2191002

Response to Request for Information for Eastern Creek Quarter - Lot 3 Concept Plan (SSD-10457)

INTERSECTION LAYOUT - CONCEPT LINEMARKING PLAN
SCALE: 1:250 @A1

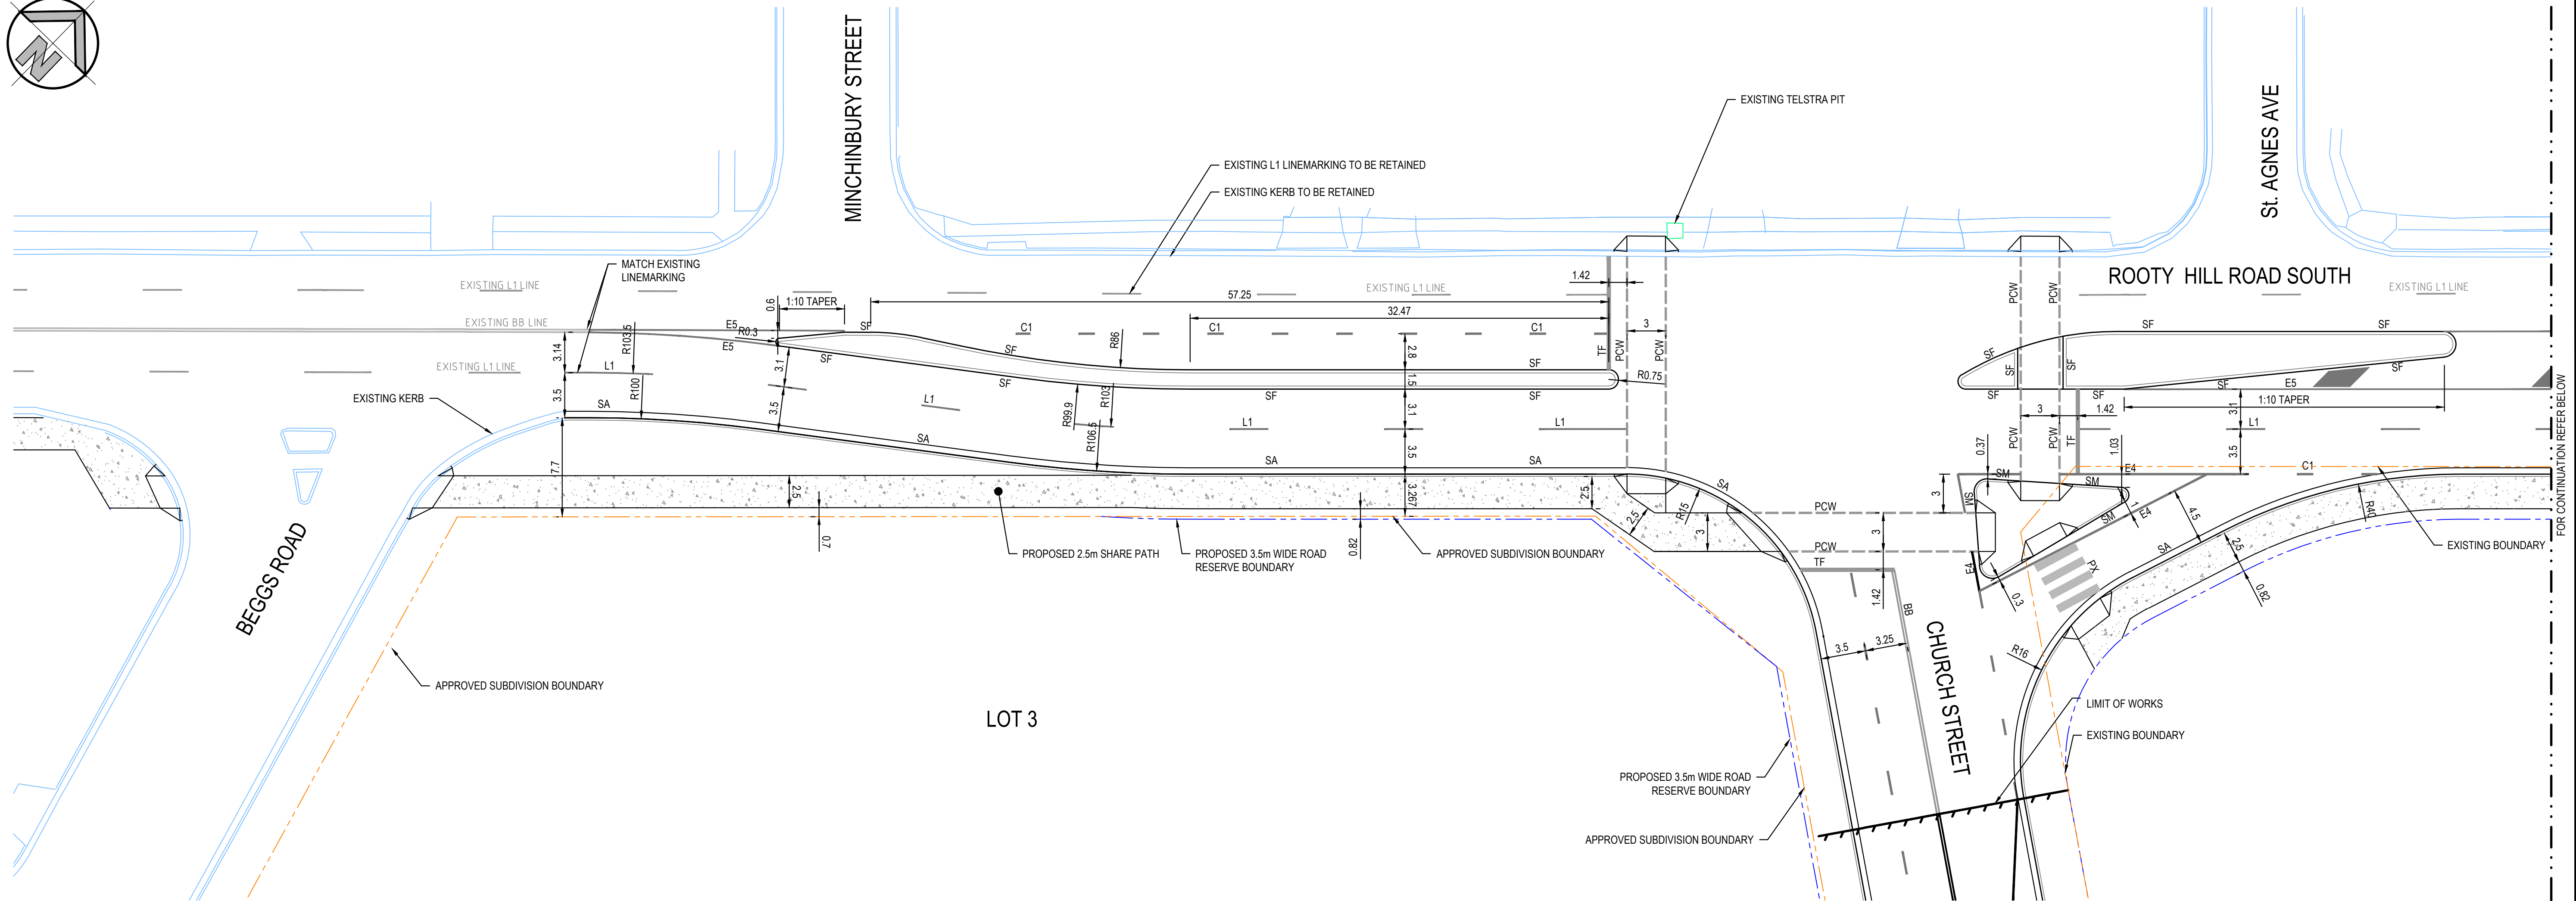
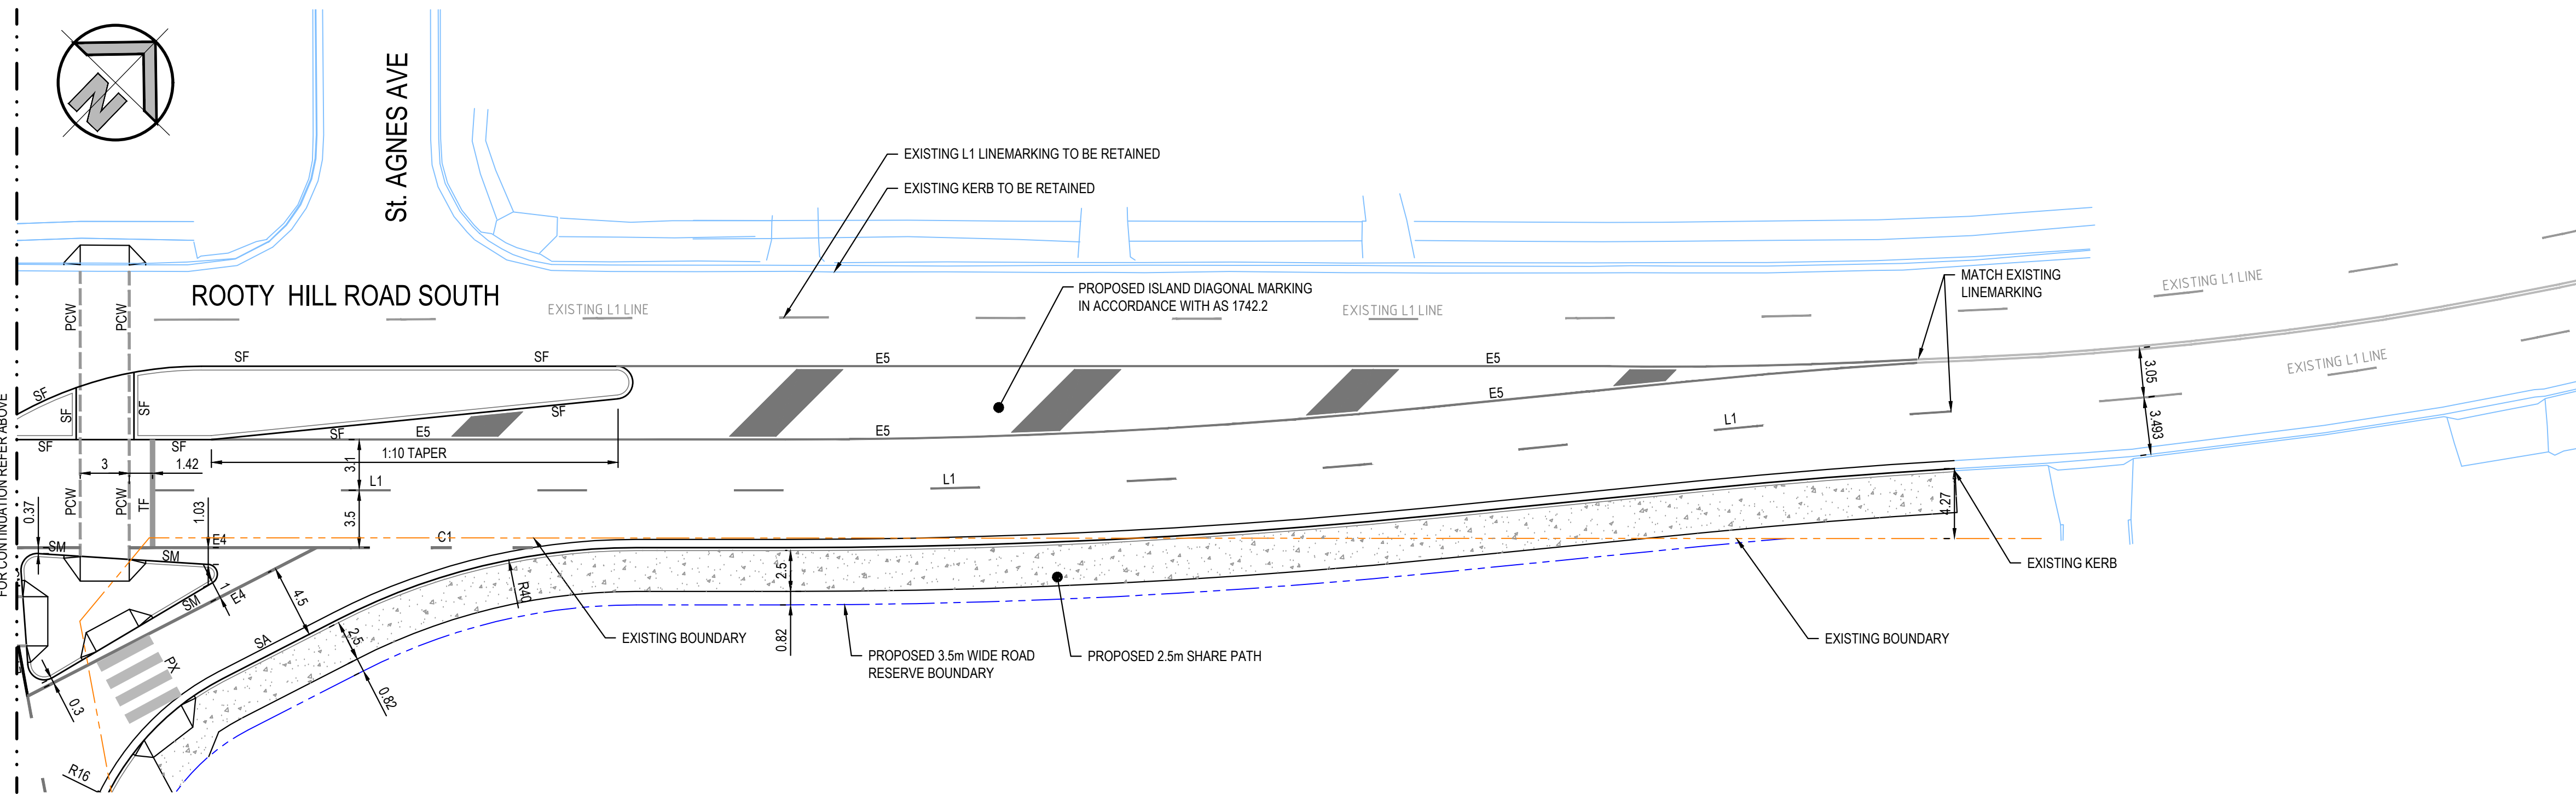
Matter raised	Response
TfNSW Submission	
We require additional information in response to the items raised by TfNSW in its letter dated 7 September 2021. This should include consideration of any alternative options which would enable access to the proposed outlet centre while managing/mitigating impacts on Rooty Hill Road South and affected local streets, in consultation with TfNSW and Council as required.	<p>Since receiving their initial submission, ongoing consultation has occurred with TfNSW regarding the necessary intersection upgrades in accordance with Council's preferred concept design involving traffic signals. As part of this consultation, a preliminary response to the submission was sent to TfNSW on 18 October 2021 which included a revised intersection concept design and a meeting was subsequently held on 21 October 2021 to discuss.</p> <p>At this meeting, it was acknowledged that the design principles and response were generally consistent with TfNSW's previous feedback and it was agreed that the intersection concept design would be updated to show:</p> <ul style="list-style-type: none"> • A single pedestrian crossing; • A left turn high angle slip lane; • Median extended to prohibit right hand turns to/from St Anges Ave and Minchinbury Street. <p>CBRK has since provided the attached response to TfNSW (Attachment A) which addresses these matters.</p> <p>It is noted that the 3.5m wide road reserve for Church Street south shown on the revised concept intersection is already accommodated by the proposed plan of subdivision accompanying this application. As outlined in the previous RFI response (dated 16 October 2021), and as shown on the current intersection concept, works to Morreau Reserve would be required to accommodate the left turn slip lane to TfNSW standards. The final design of this intersection will</p>

Matter raised	Response
	seek to minimise the extent of works required in this area and this will be addressed as part of a future WAD process for the delivery of the intersection upgrades.
Economic Impacts	
Clarify the term 'Urban Renewal Precincts' in the addendum economic statement.	The term 'Urban Renewal Precincts' has been taken from Blacktown City Council's Local Strategic Planning Statement (LSPS) in response to Council's original submission which requested that the economic impact assessment reflect Council's hierarchy of centres. Accordingly, the assessed localities were grouped into centres corresponding with Council's identified centres in their LSPS.
Detail how the 'balance of centre' groupings for strategic centres and key centres align with the economic impact assessment provided with the EIS.	The impact analysis in the Macroplan EIA focused on the key shopping centres in the identified strategic and key centres, as the potential impacts from Eastern Creek Quarter would mostly fall on these facilities. Uses in the 'balance of centre' were not specifically covered in the impact analysis provided in the EIA. The Economic Advice letter addresses the potential impacts on the 'balance of centre' uses for completeness, and confirms that the impacts on the 'balance of centre' uses, excluding the major shopping centre, would be very minor.
